**From:** Jennifer Pollitt [REDACTED]  
**Sent:** 15 February 2022 16:10  
**To:** Planning.Responses <Planning.Responses@arun.gov.uk>  
**Subject:** RE: Planning Consultation on: A/270/21/OUT

**Application No:** A/270/21/OUT

**Site Address:** Land off Arundel Road Angmering

**Description of Works:** Hybrid application comprising: Full planning application for the development of 160 No dwellings with open space, landscaping and sustainable drainage systems (SuDs), and two vehicular access points from Arundel Road; Outline Application with all matters reserved except access for up to 1,393 sqm of Class E floorspace with associated parking provision. This site is a Departure from the Development Plan and affects the setting of listed buildings. .

8.3 ECOLOGY MITIGATION

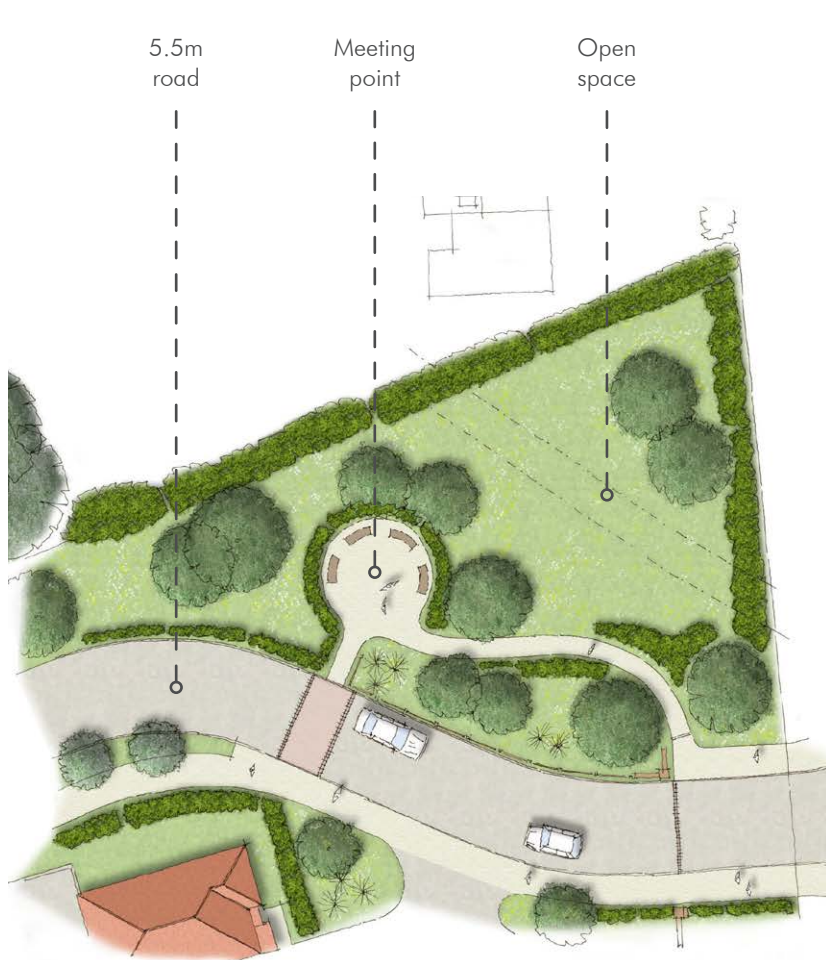
The Enhancements detailed in the Phase II Surveys Report and Ecological Mitigation and Enhancement Strategy (Dec 2021) are sufficient. These should be incorporated into the scheme and shown on the landscape plans. The plans

should reflect the recommendations made in the aforementioned reports and can be submitted for our approval as part of a reserve matters application.
